**Case Reference:**  
**ABP-308291-20**

### **Notice of Pre-Application Consultation Opinion**

**Proposed Development: 564 no. residential units (96 no. houses, 468 no. apartments), childcare facility and associated site works.**

**Former Bray Golf Club Lands, Off Ravenswell Road and Dublin Road, Bray, Co. Wicklow and Co. Dublin.**

LARGE CAR

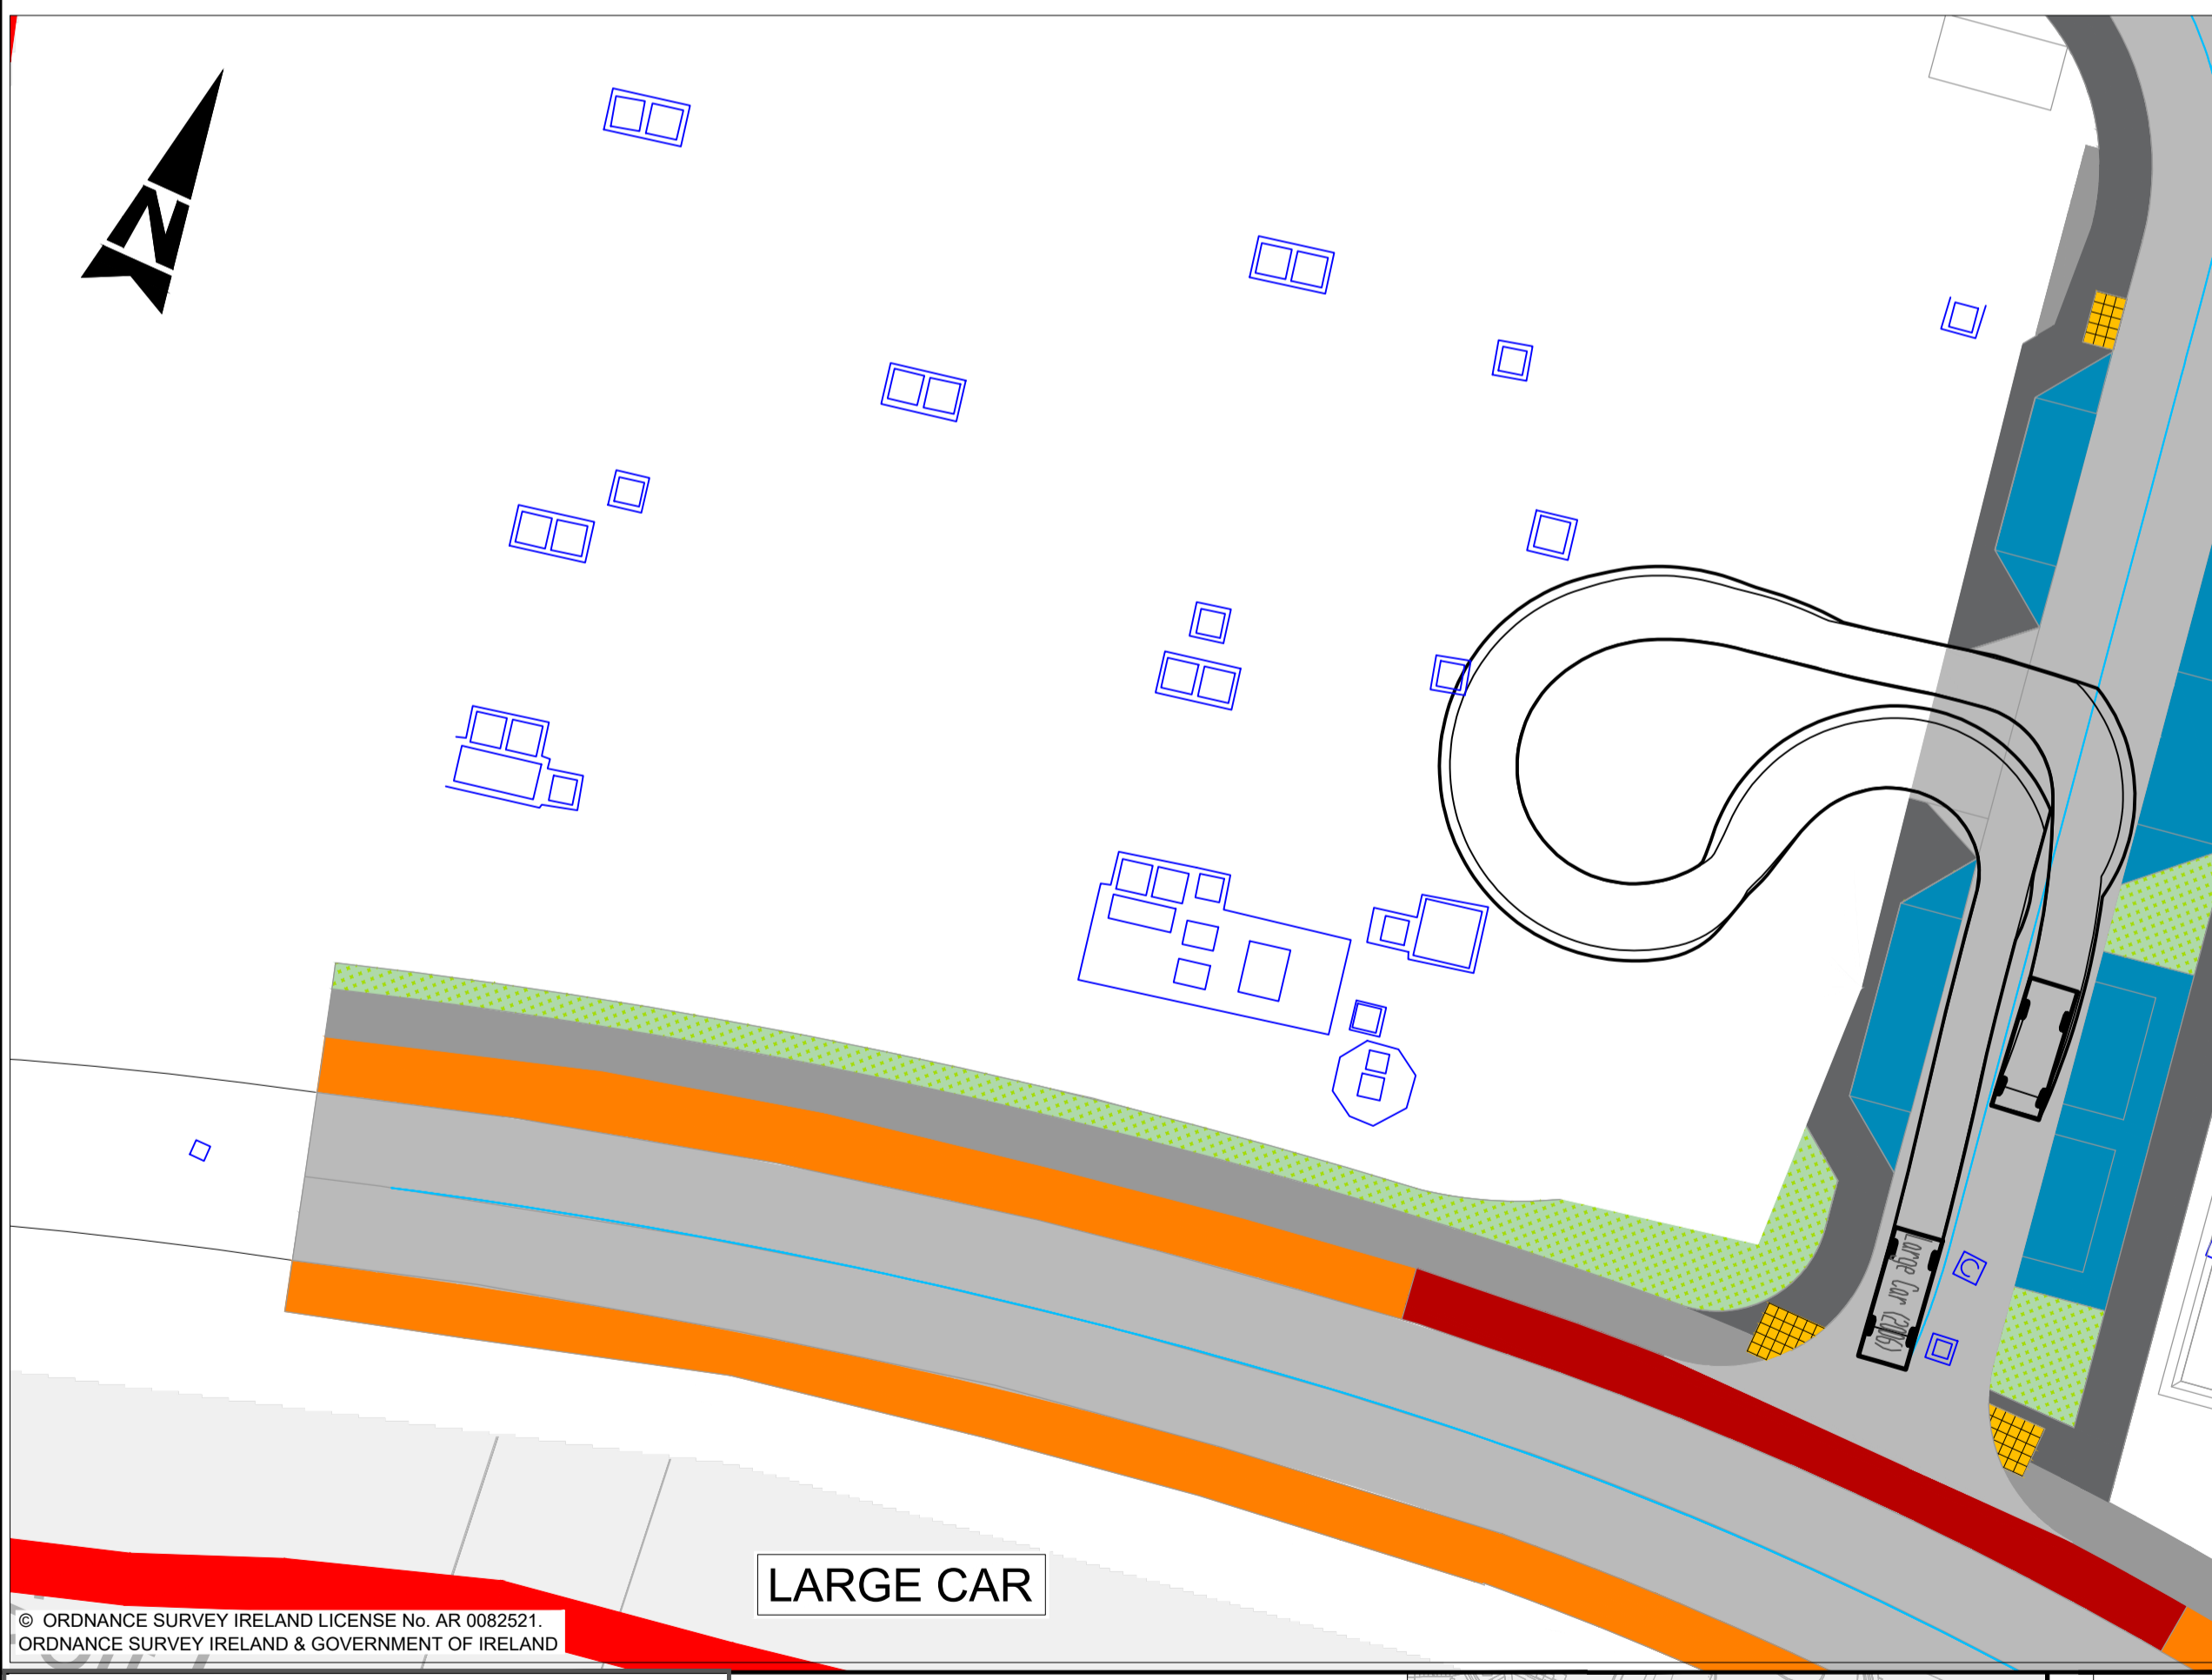
4. Further consideration of the relocation of Irish Water infrastructure located underneath 'The Orchard' in the south west portion of the site having regard to its potential negative impact on the development potential of the site and the public realm. In the event that the infrastructure is not to be relocated then a justification should be submitted at application stage that seeks to address, *inter alia*, the potential negative impact on the development potential of the site and the public realm at this location.
